**KIRKLEES METROPOLITAN COUNCIL
INVESTMENT & REGENERATION SERVICE**

Reference No:	2024/62/93198/W
Site Address:	22, Goldcrest Court, Netherton, Huddersfield, HD4 7LN
Description:	Erection of first floor extension to front and single storey side and rear extensions including associated works.
Recommending Officer:	Lucy Taylor

Officer Report.

title:
Proposed Plans and Elevations

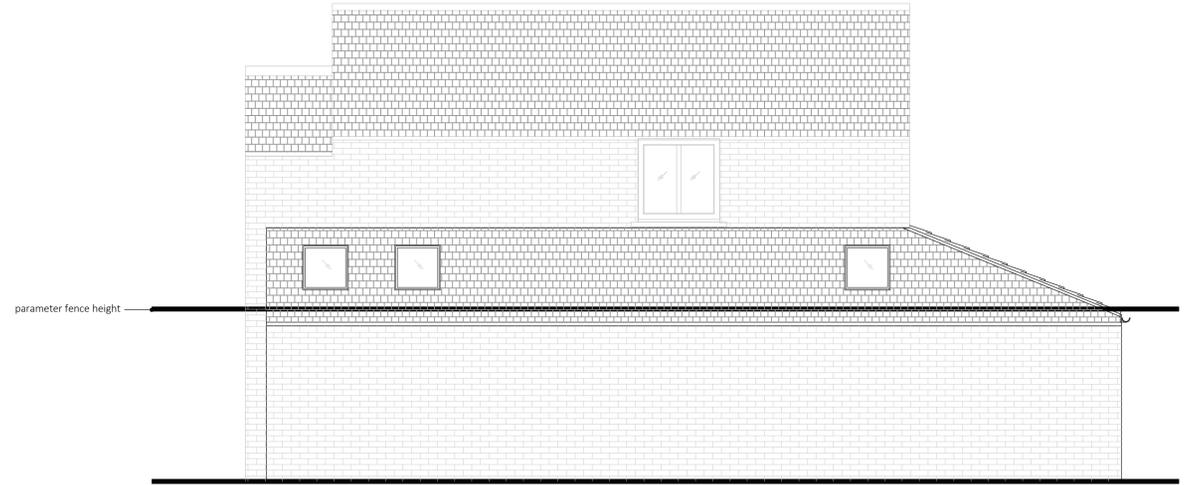
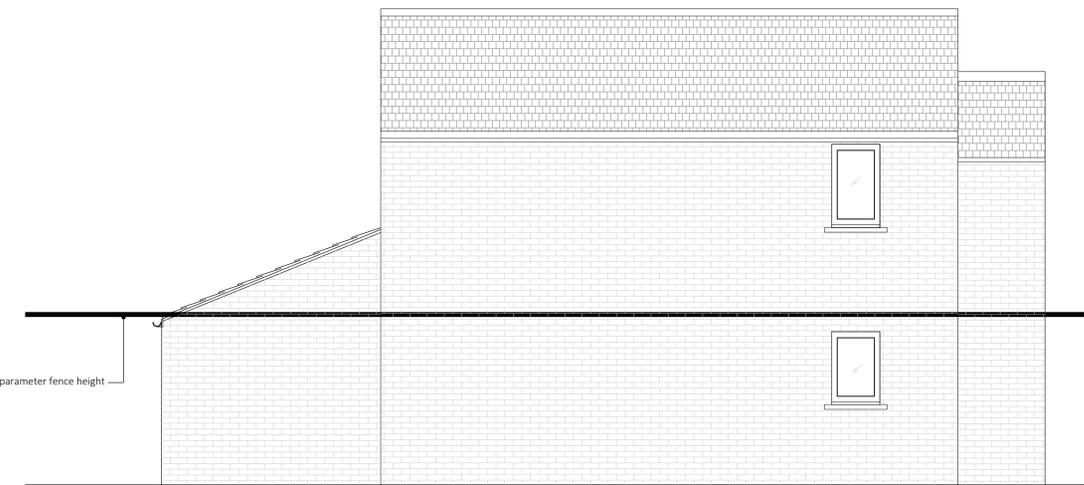
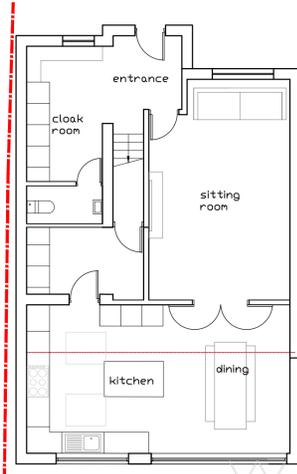
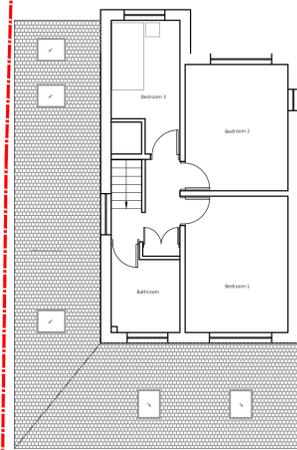
The proposed extension to the front would see a first-floor gable element added. The property currently benefits from a single storey gable roofed projection to the front elevation. The proposed first-floor extension would have the same projection as this existing single storey element (1.2 metres) and is considered to be sufficiently set down to support an overall subservient appearance. The extension would be faced in matching reconstituted yellow stone and the roof would be infilled with matching concrete roof tiles.

The side extension would have a projection from the host property of 1.8 metres, equivalent to a projection of one third of the width of the original house. Therefore, the projection of the proposed side extension is considered to appropriately accord with the design recommendations of the House Extensions and Alterations SPD as set out above. In addition, the side extension is to retain a separation distance of 0.5 metres from the shared boundary, preserving a sense of openness around the site.

The proposed side extension will be set back from the original building line of No. 22 Goldcrest Court by approximately 0.3 metres. Whilst this is below the recommendation within the House Extensions and Alterations SPD, it is considered to be sufficient in this instance. A set back of 0.3 metres is

The proposed rear extension will have a projection of 4 metres, with 22 Goldcrest Court being a detached dwelling. In addition, the height of the rear extension will be 4 metres. As such, the size / scale of the proposed extension is considered to appropriately accord with the design recommendations of the House Extensions and Alterations SPD, with a significant extent of outdoor amenity space to be retained to the rear of the dwelling following development.

Whilst officer's note that the rear extension would retain a separation distance of approximately 0.7 from the shared boundary, rather than a one metre as recommended within the House Extensions and Alterations SPD, in this instance, such a separation is considered to be adequate. A separation distance of 0.7 metres will retain an appropriate sense of openness around the site.

Proposed Site Plan
Scale 1:500

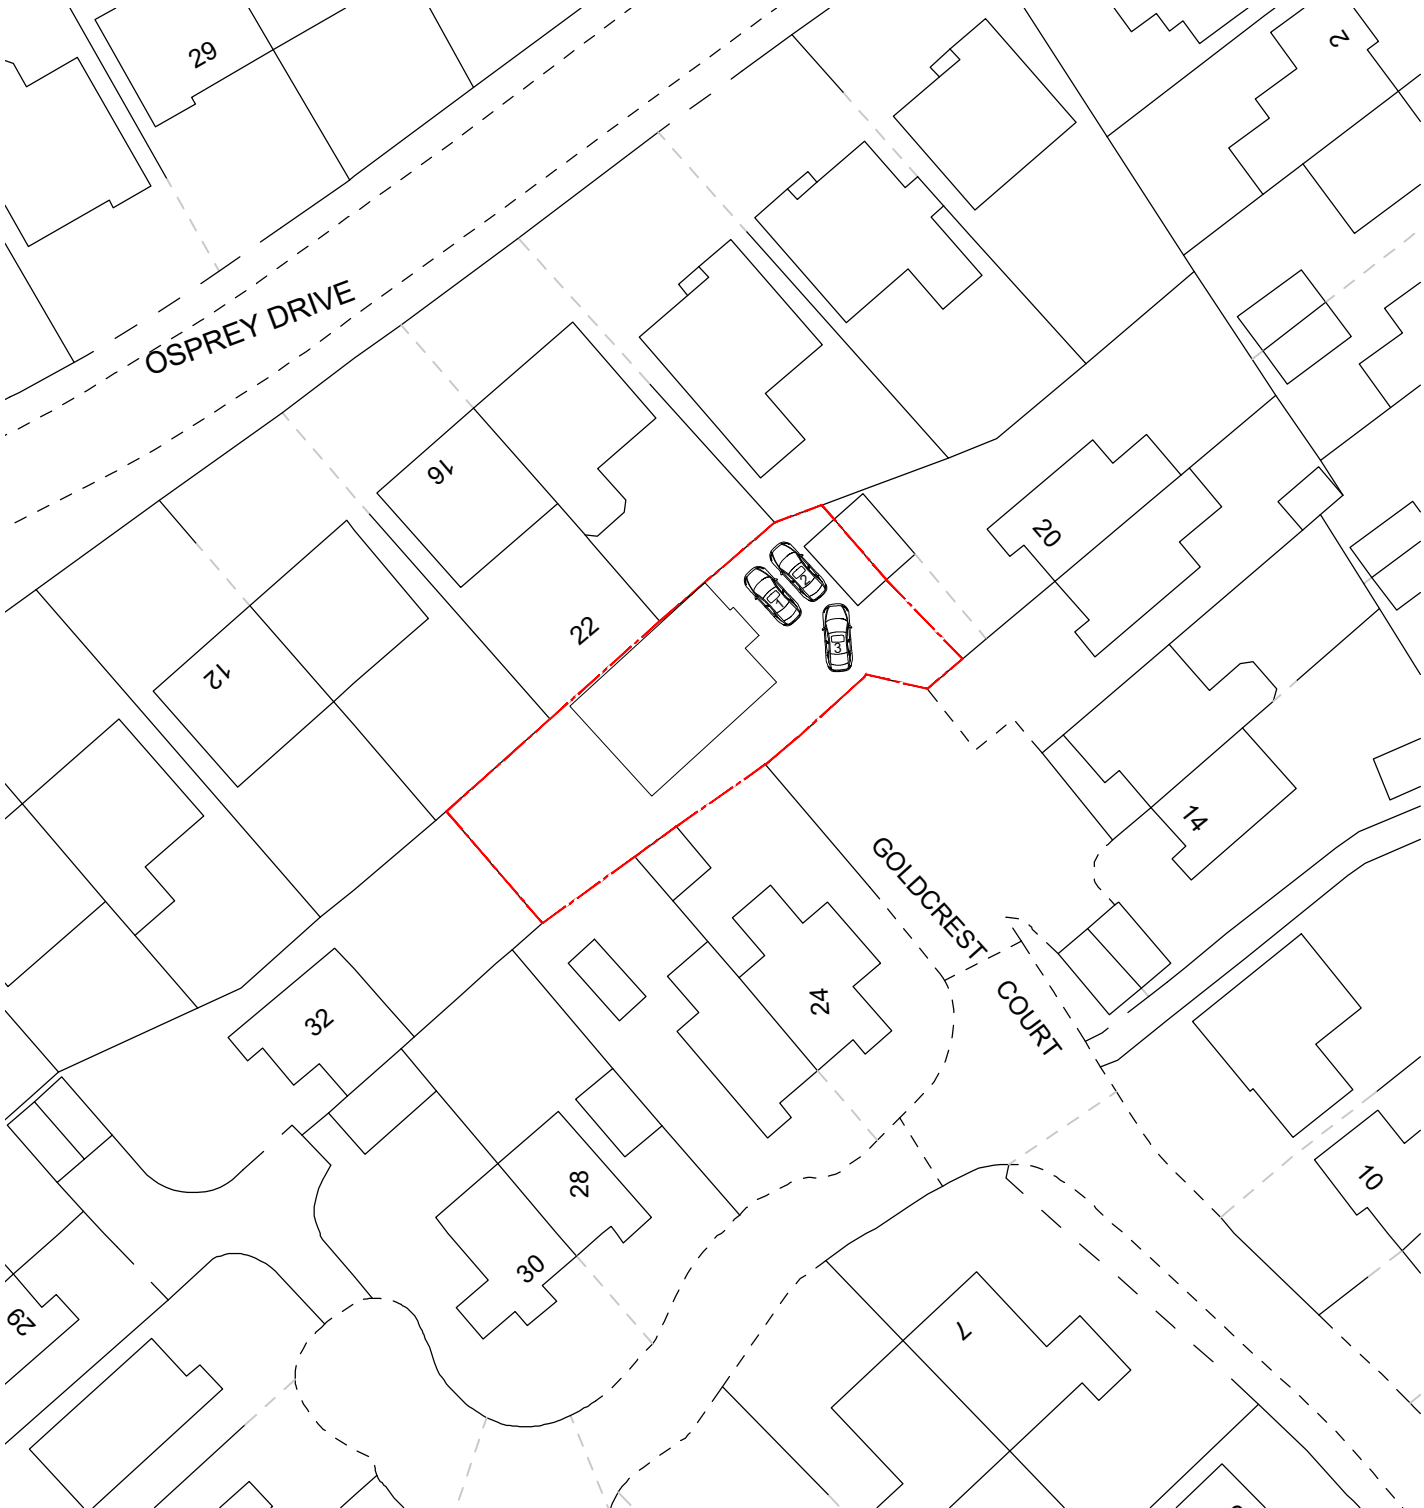
The submitted 'proposed site plan' shows three on-site parking spaces to be retained at No. 22 Goldcrest Court.
